DEVELOPMENT REVIEW BOARD  
TRANSPORTATION DEVELOPMENT

DRB Project Number: 1011573  
**Atrisco Business Park Unit 2**

SUBJECT: Site Plan for Building Permit

Application #: 18DRB-70114

SHEET TITLE:
SITE PLAN
FOR BUILDING
PERMIT

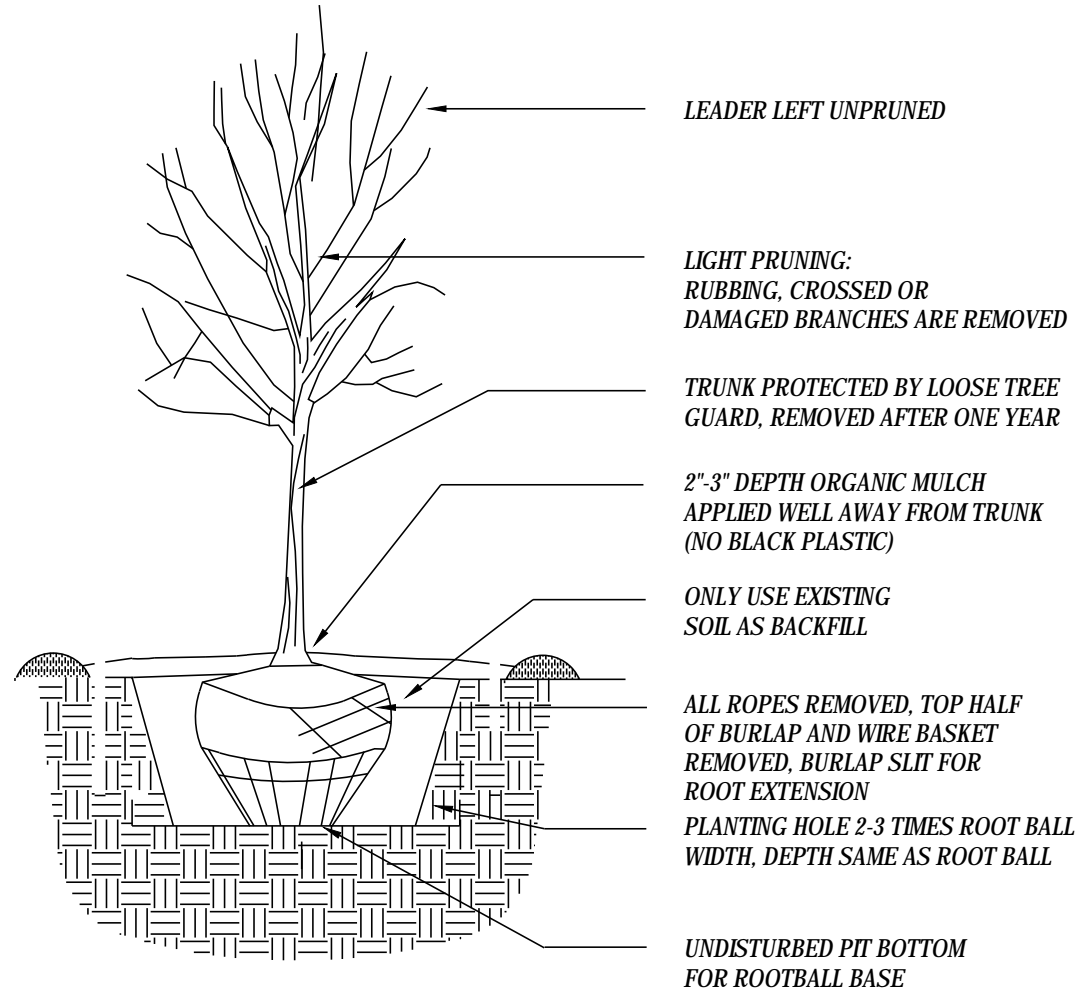
1. Please list the width and length for all existing and proposed parking spaces. Some dimensions are not shown.
2. The ADA accessible spaces must include an access aisle. Van accessible aisles should be 8ft wide; all others should be 5ft wide.

5. Per DPM, a 6 ft. wide ADA accessible pedestrian pathway is required from the HC parking stall access aisles to the building entrances. Please clearly show this pathway and provide details.

6. Please add the clear sight triangle to each subdivision entrance. Add the following note as well: "Landscaping, fencing and signing will not interfere with clear sight requirements. Therefore, signs, walls, trees, and shrubbery between 3 and 8 feet tall (as measured from the gutter pan) will not be acceptable in the clear sight triangle."

7. Where are the motorcycle spaces located?
8. Per the zoning code, a 6 ft. wide ADA accessible pedestrian pathway is required from the public sidewalk to the building entrances. Please clearly show this pathway and provide details.

9. Provide public sidewalk easement for portion of sidewalk not in the right of way.

4 HANDICAP ACCESSIBLE PARKING LAYOUT

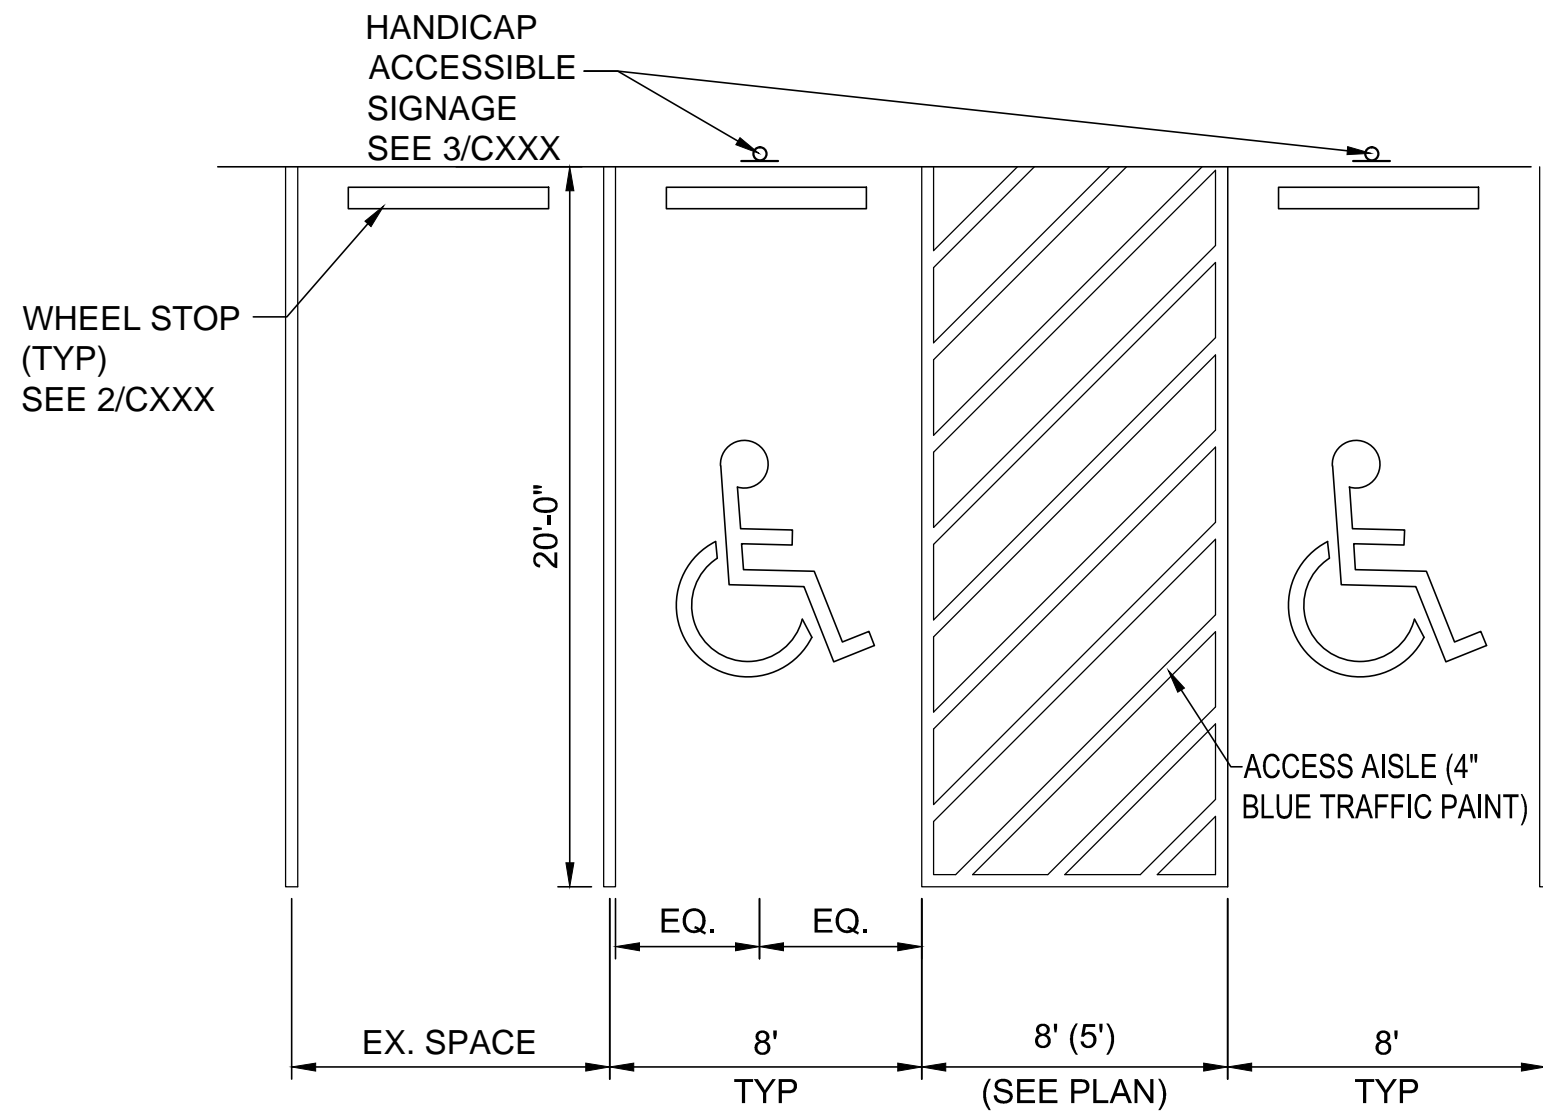
3. The ADA access aisle shall have the words **"NO PARKING"** in capital letters, each of which shall be at least one foot high and at least two inches wide, placed at the rear of the parking space so as to be close to where an adjacent vehicle's rear tire would be placed. (66-1-4.1.B NMSA 1978)

5 HANDICAP ACCESSIBLE PARKING SIGN

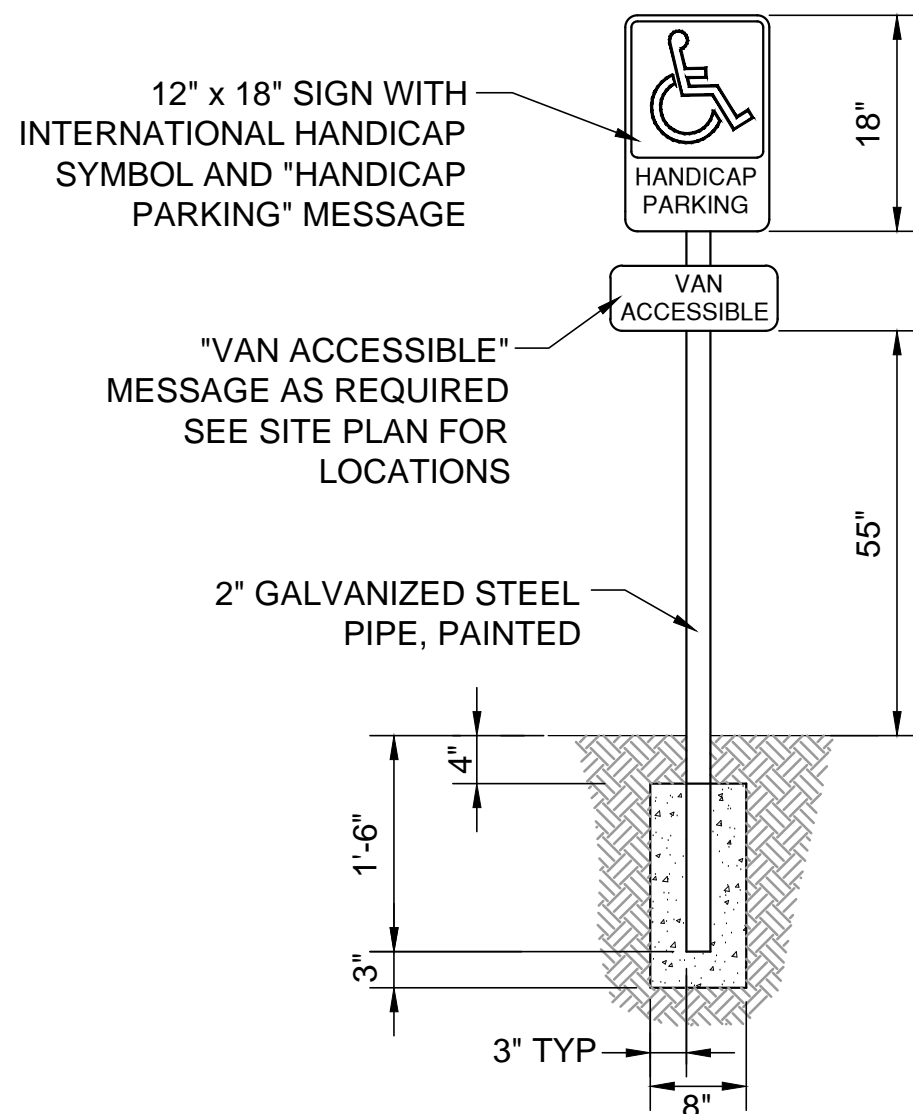
4. The ADA accessible parking sign must have the required language per 66-7-352.4C NMSA 1978 **"Violators Are Subject to a Fine and/or Towing."** If that language is present it is not visible in the detail.

SHEET TITLE:
EXTERIOR
ELEVATIONS

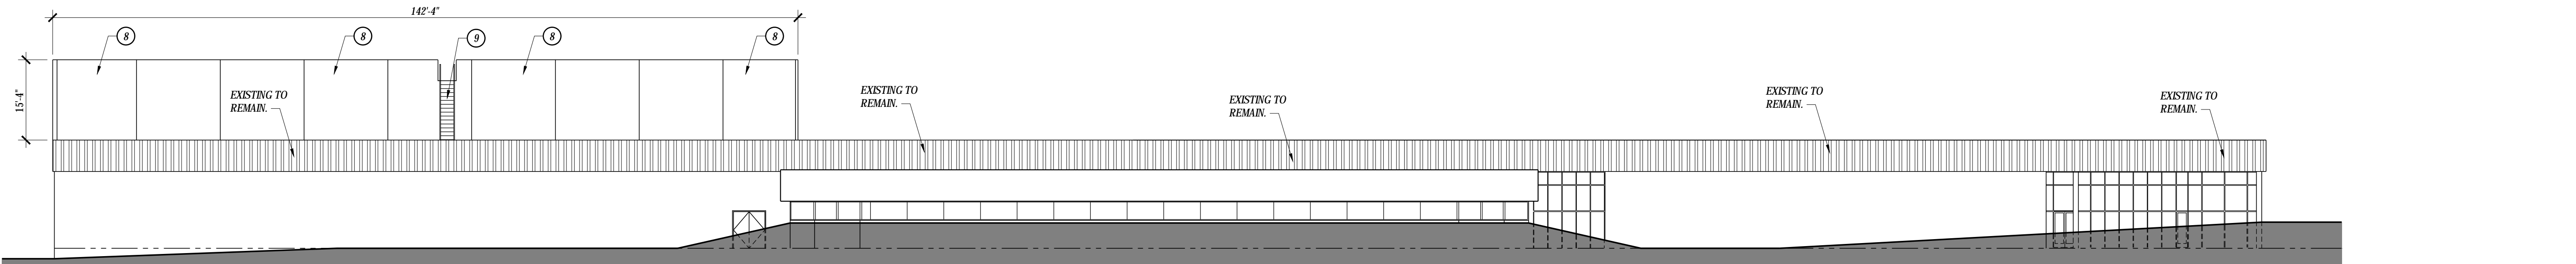
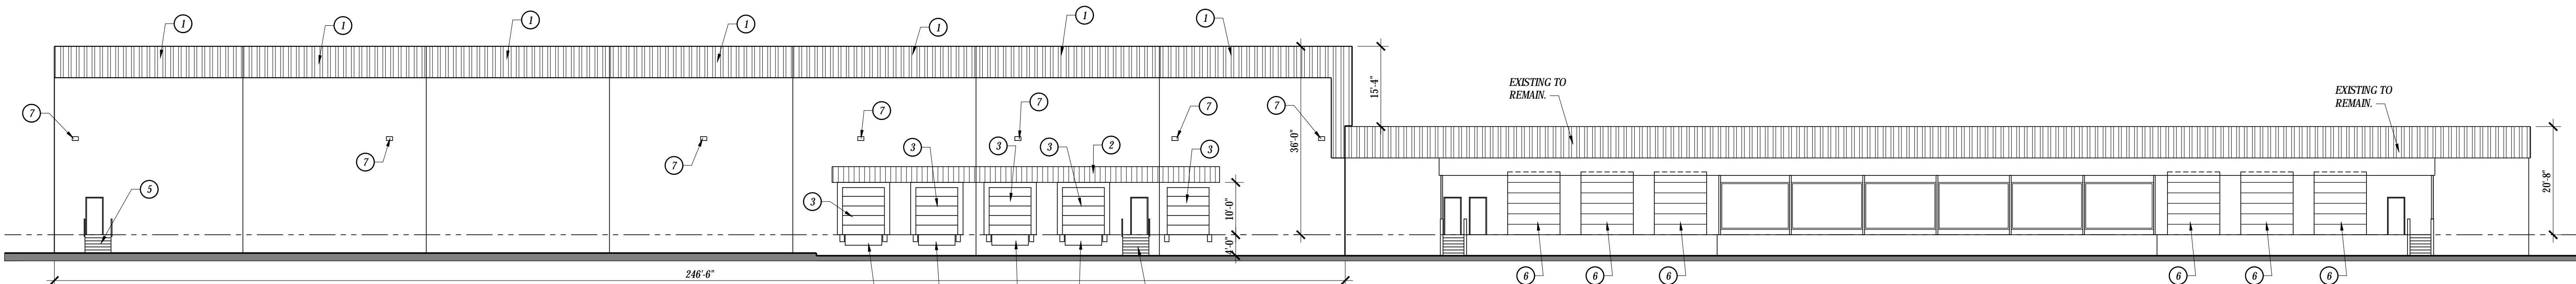
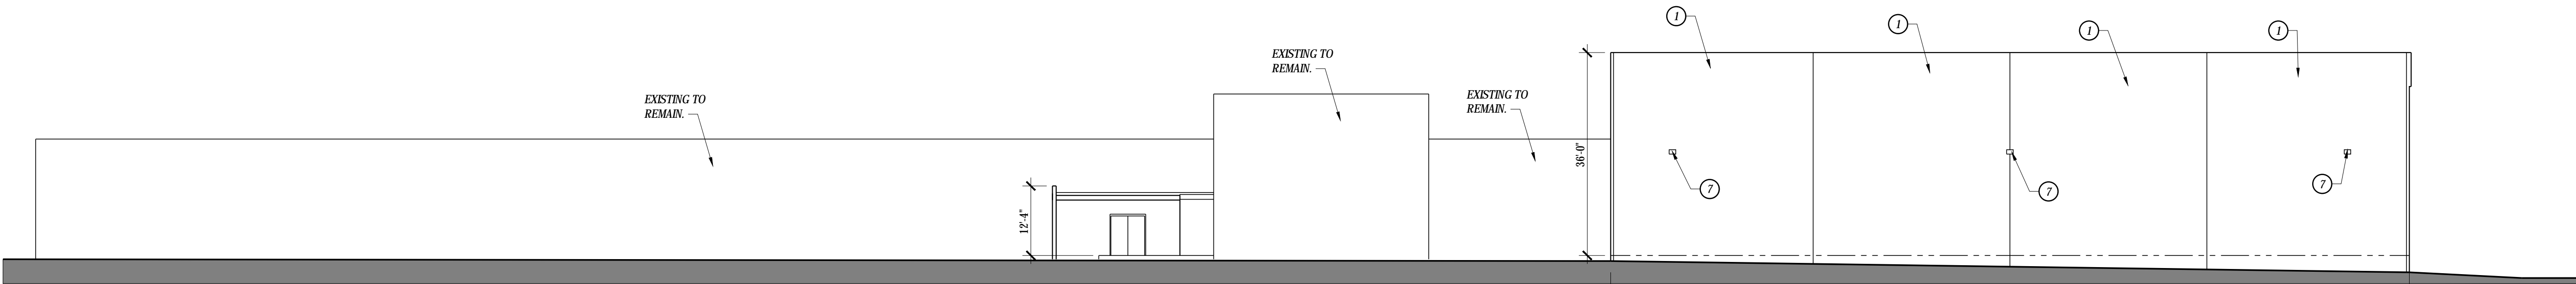
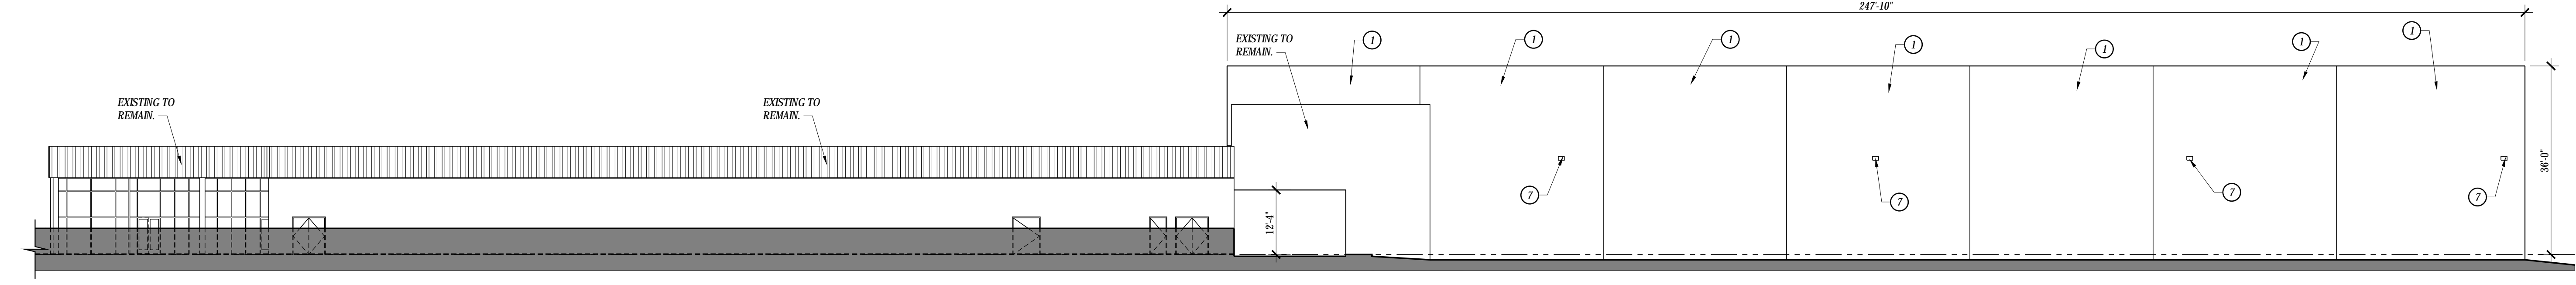
- Total building height of addition should be labelled on building elevation sheet.
- Should be labelled clearer what is existing and what is proposed on building elevations sheet.
